Application no: H05/0892/95

Description: Remove brickwork to enable
garage door to front and patio
doors to rear to be installed

Location: The Village Hall
Hallgate
Fleet
Spalding Lincs

TOWN AND COUNTRY PLANNING ACT 1990
NOTICE OF ACCEPTANCE OF AMENDMENT

DRAWING No.:
LS.2.C

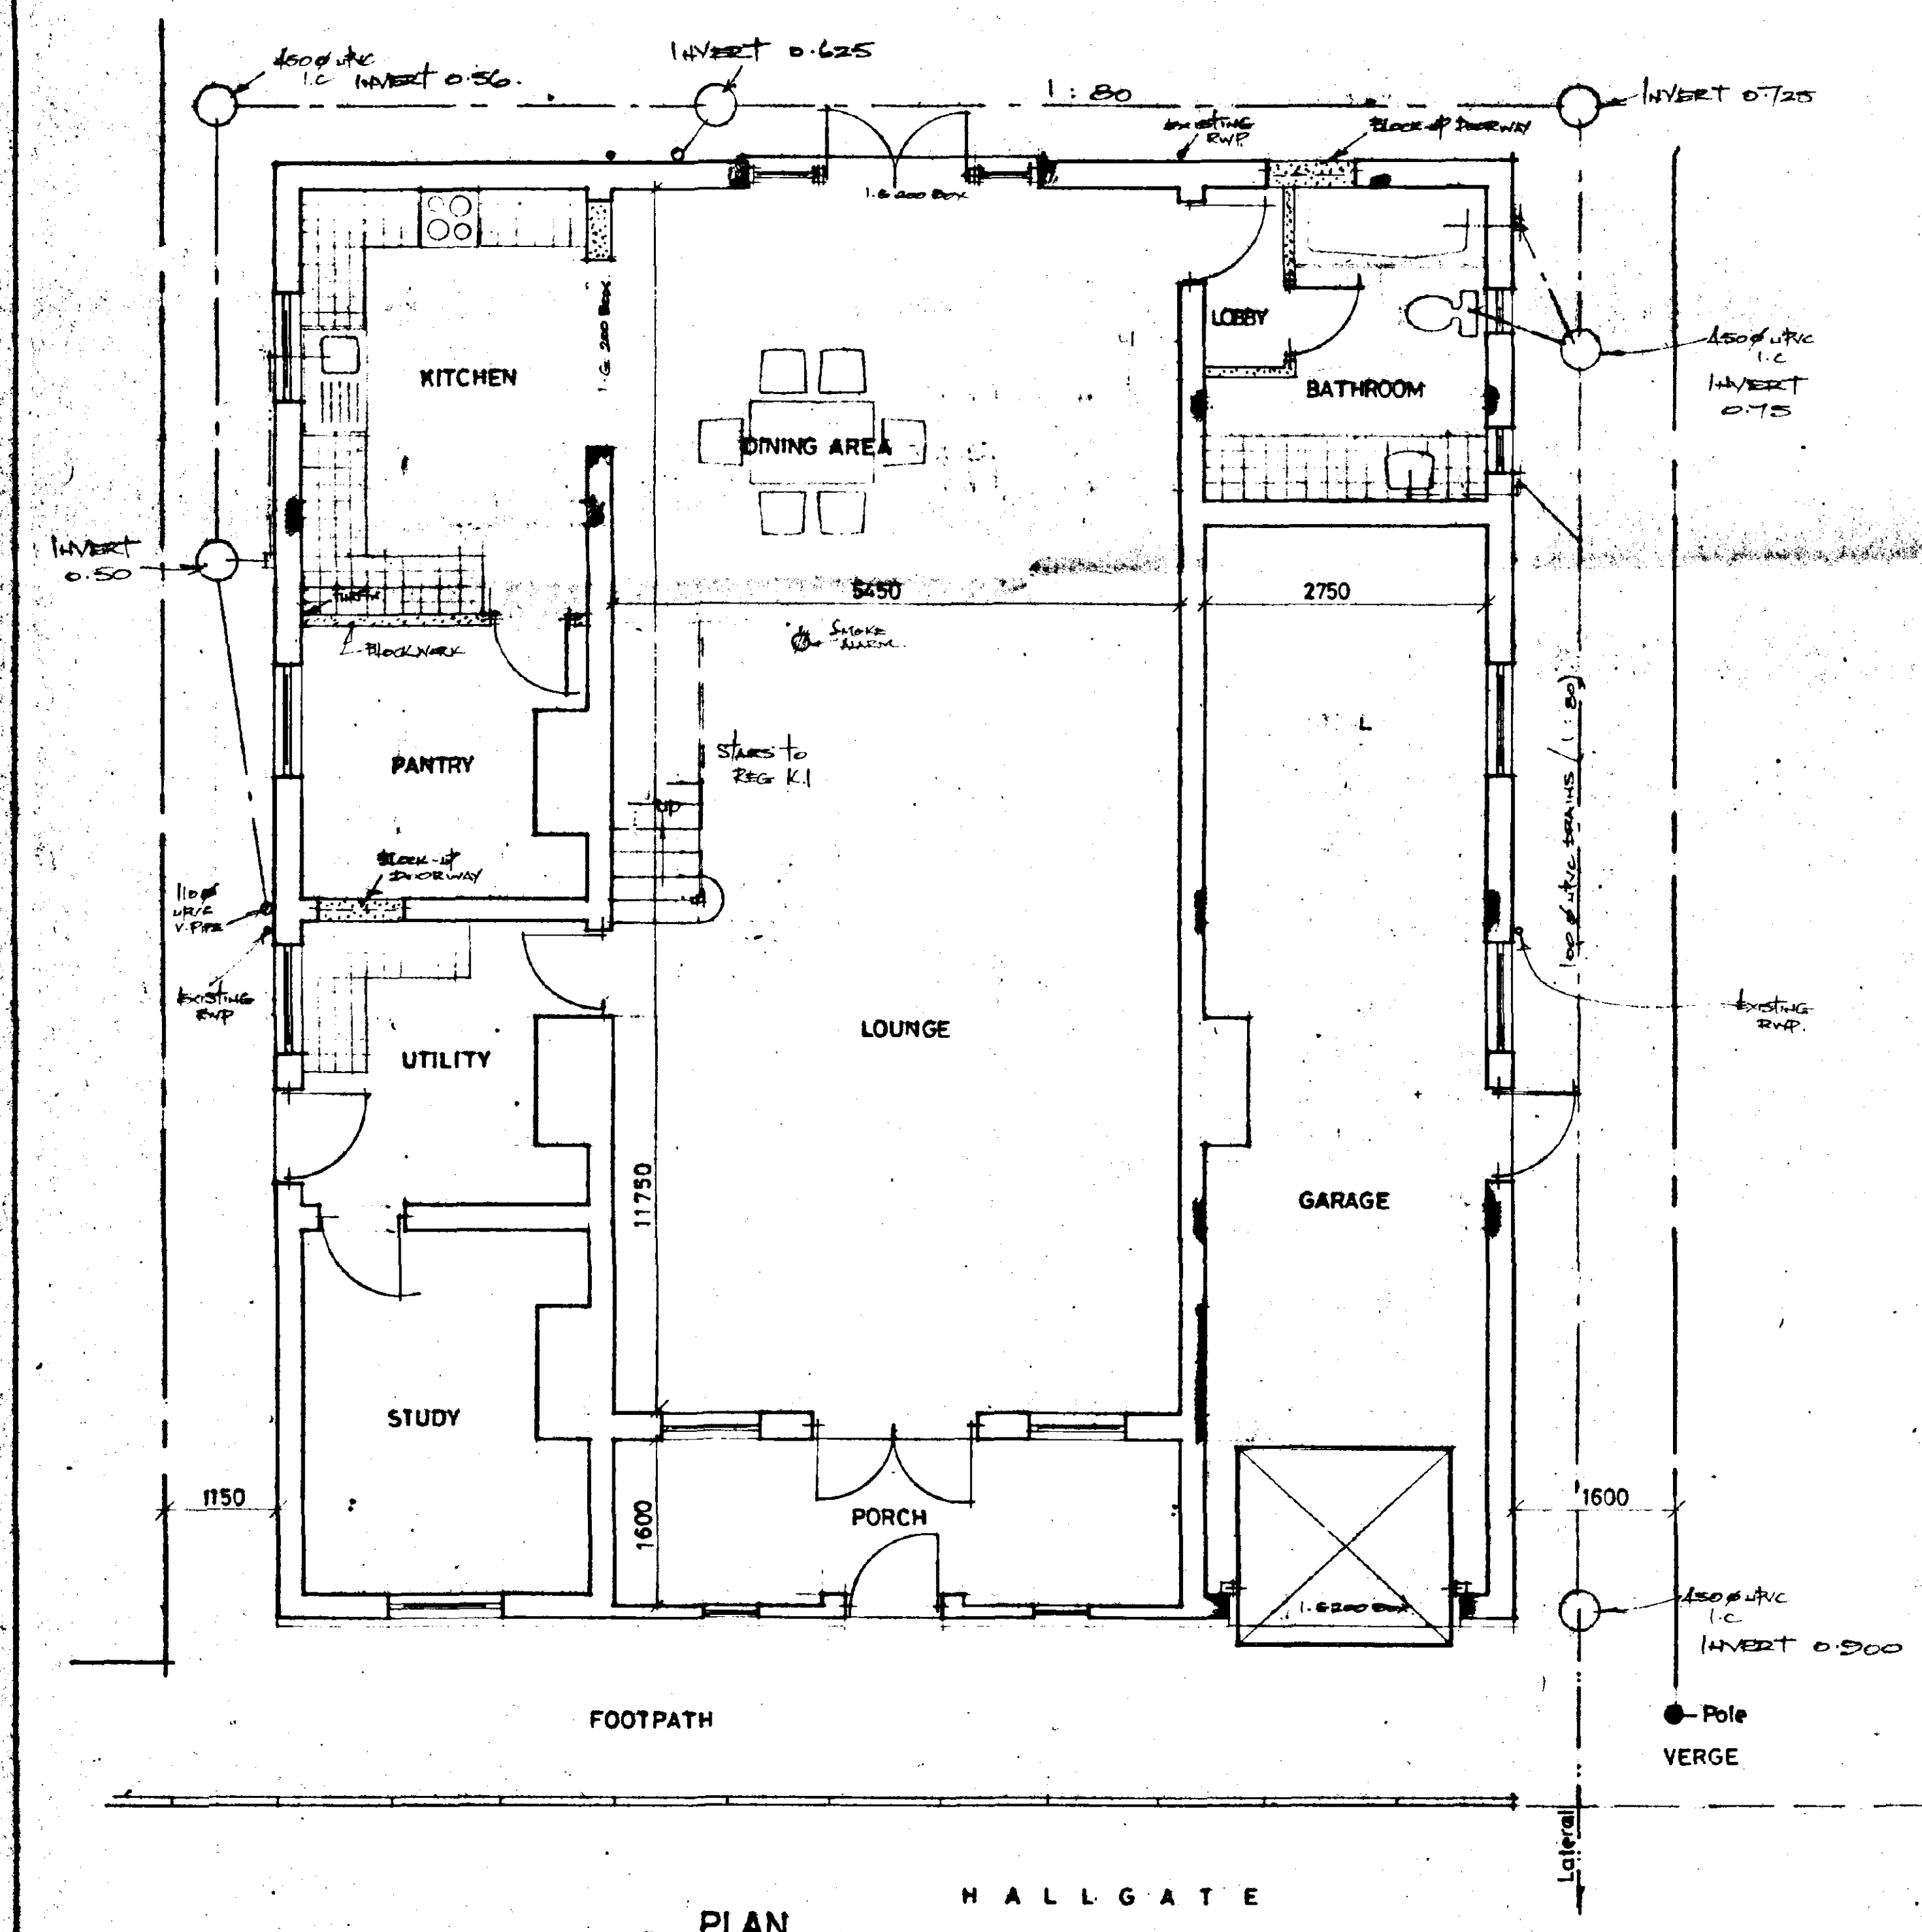
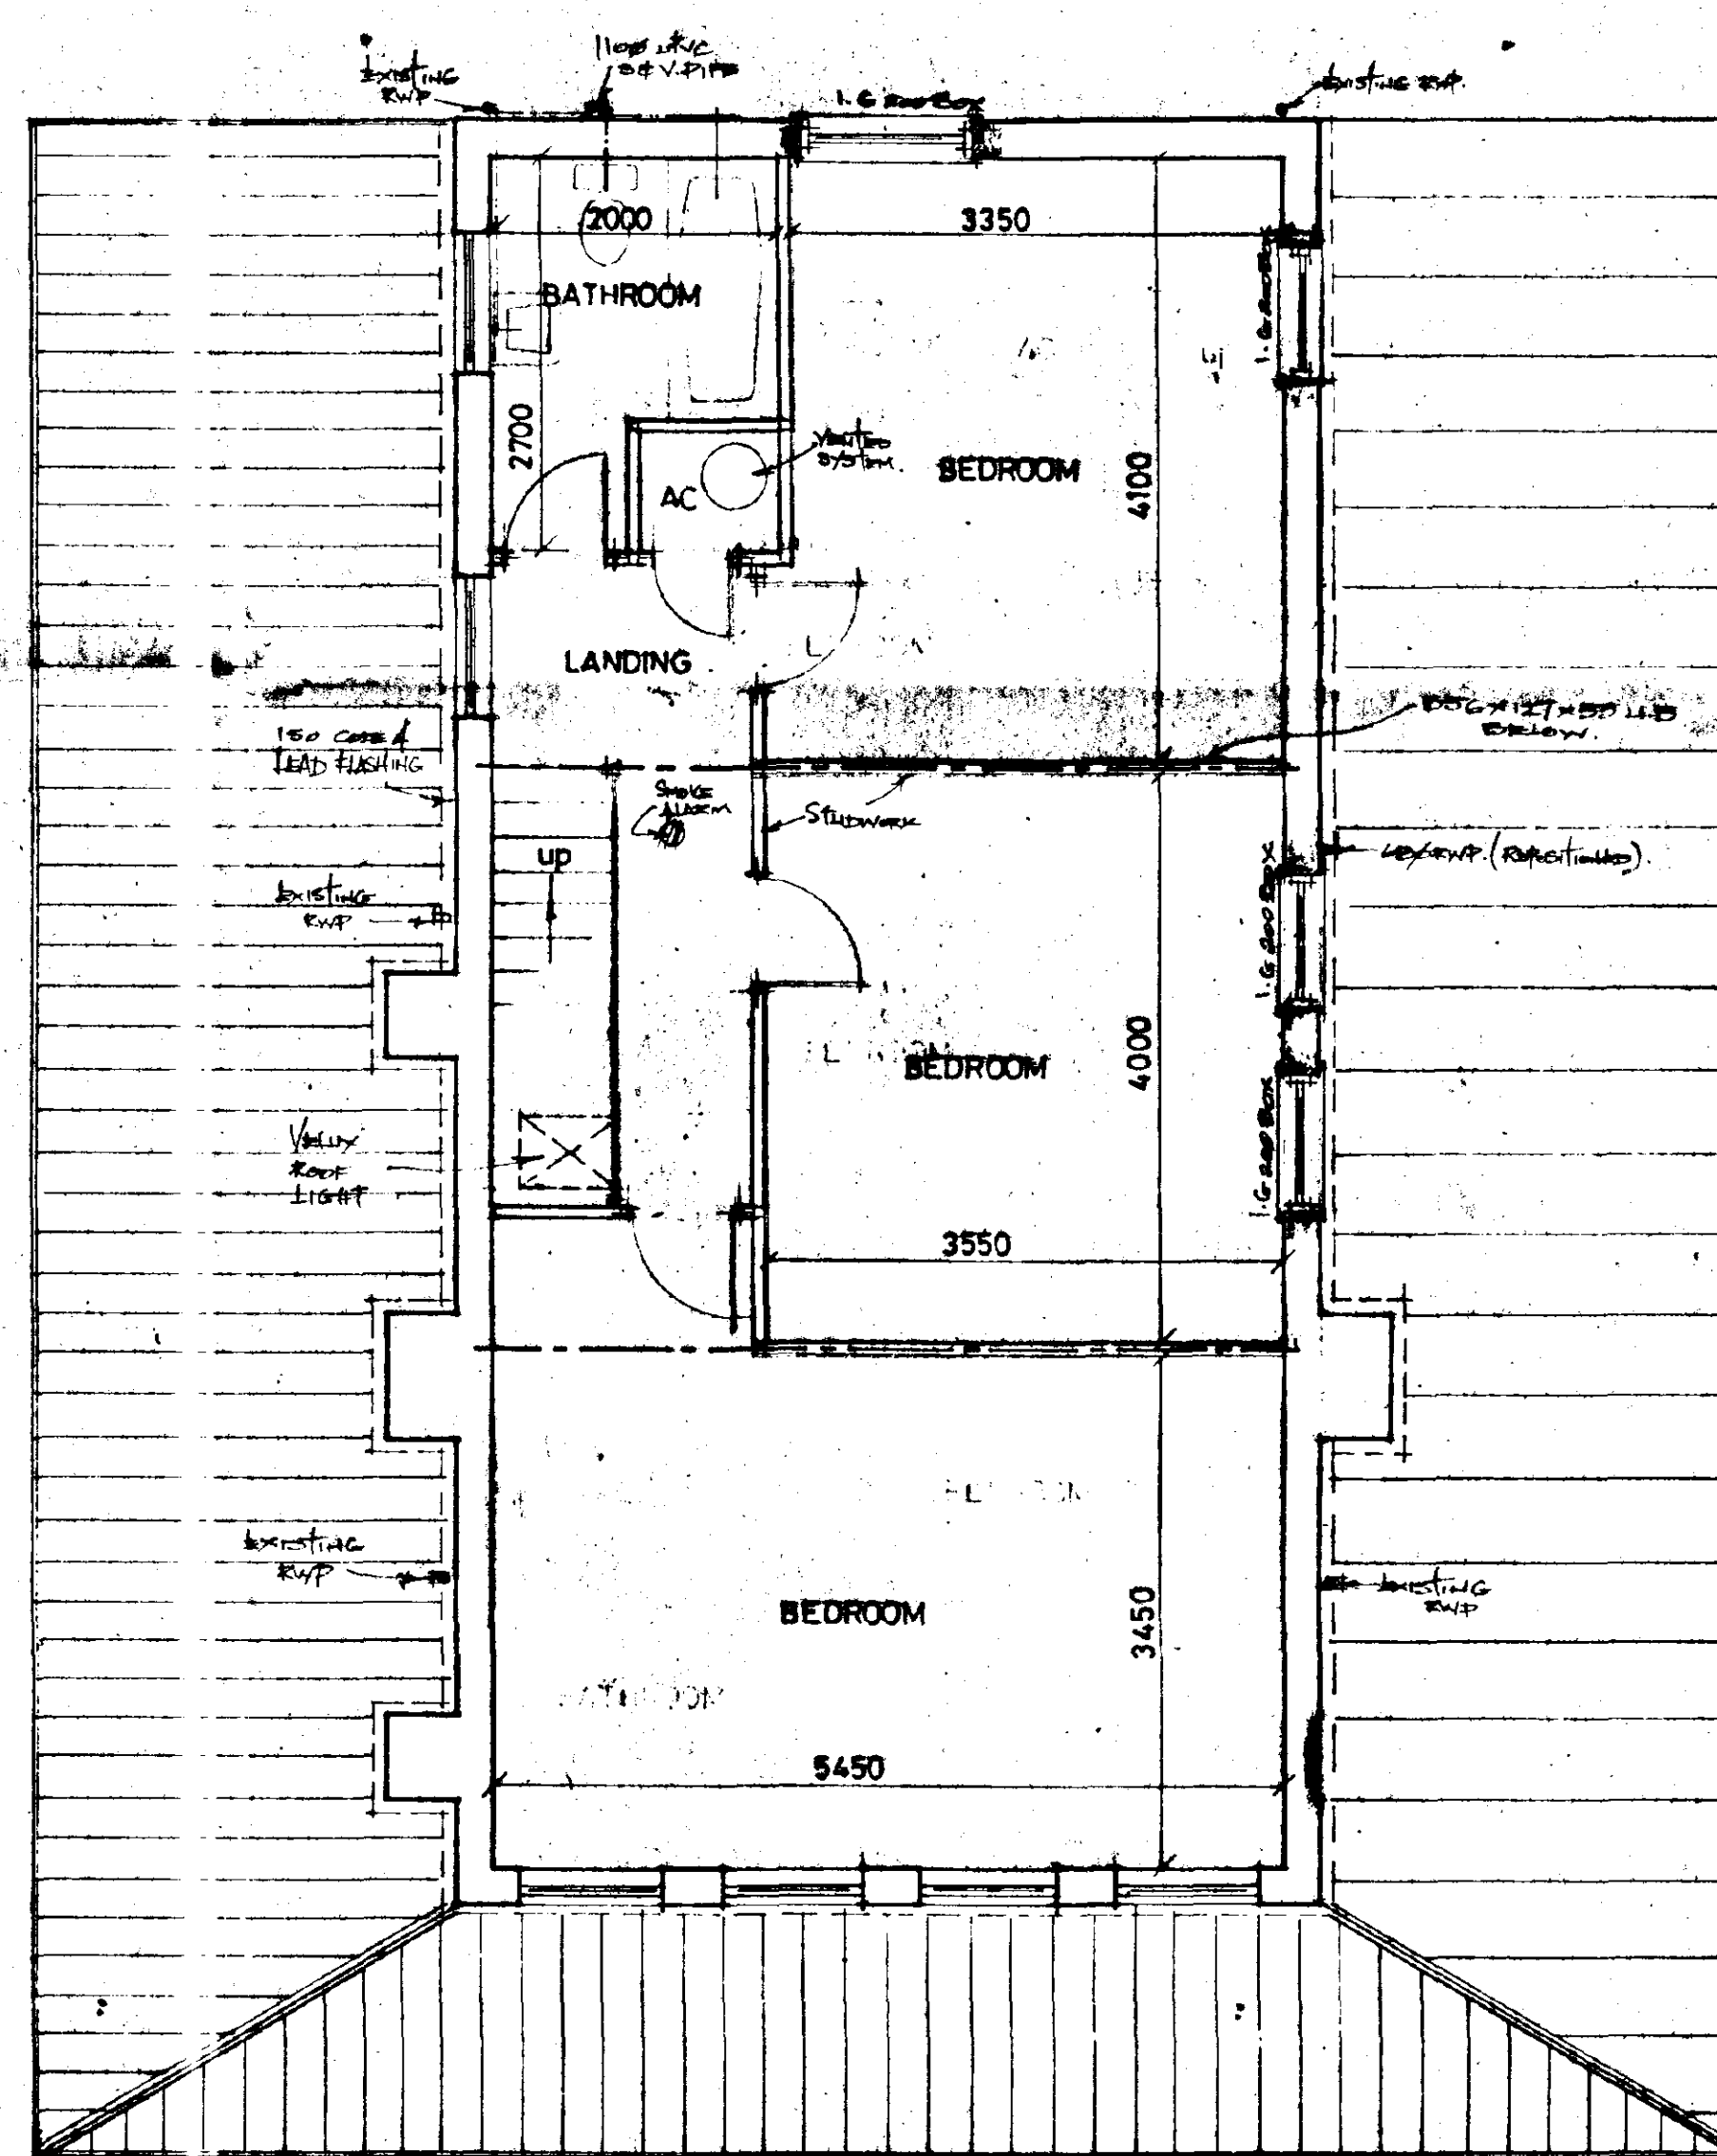
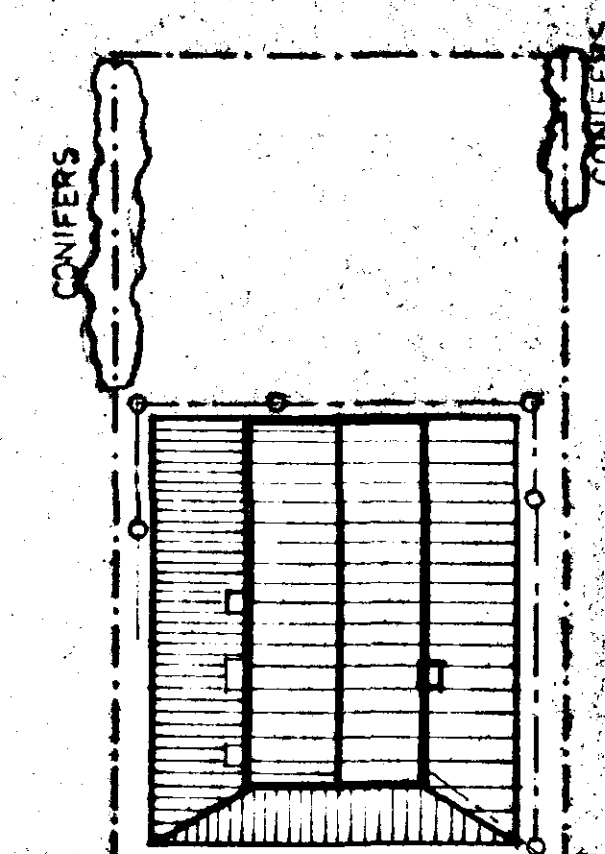
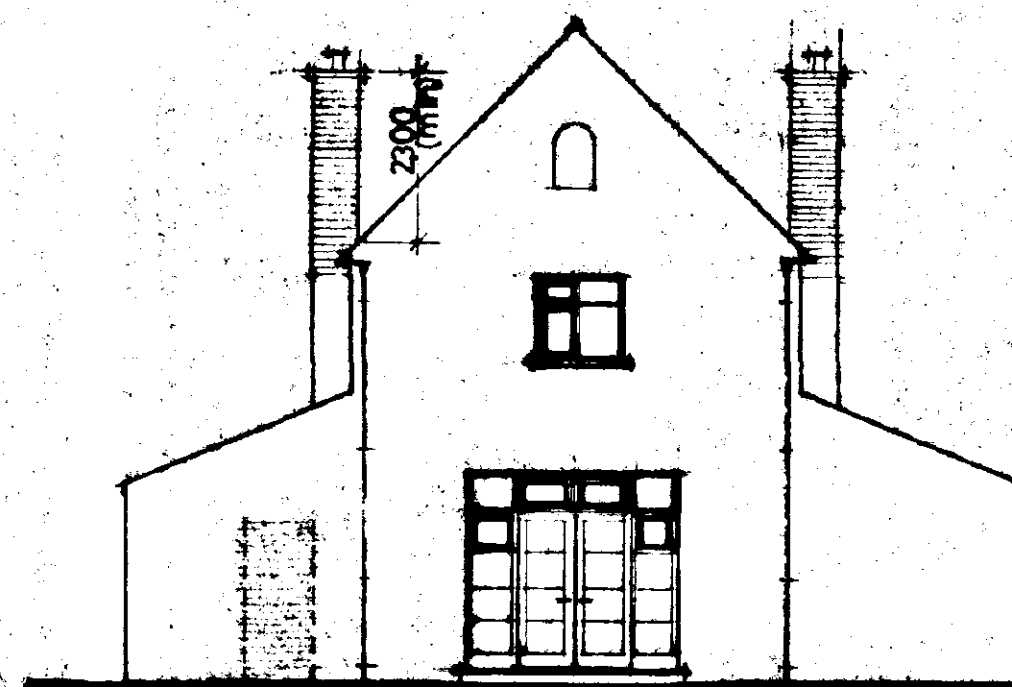
RAISE STAKES.

Amendment: Raise stacks
(drawing number LS.2.C)
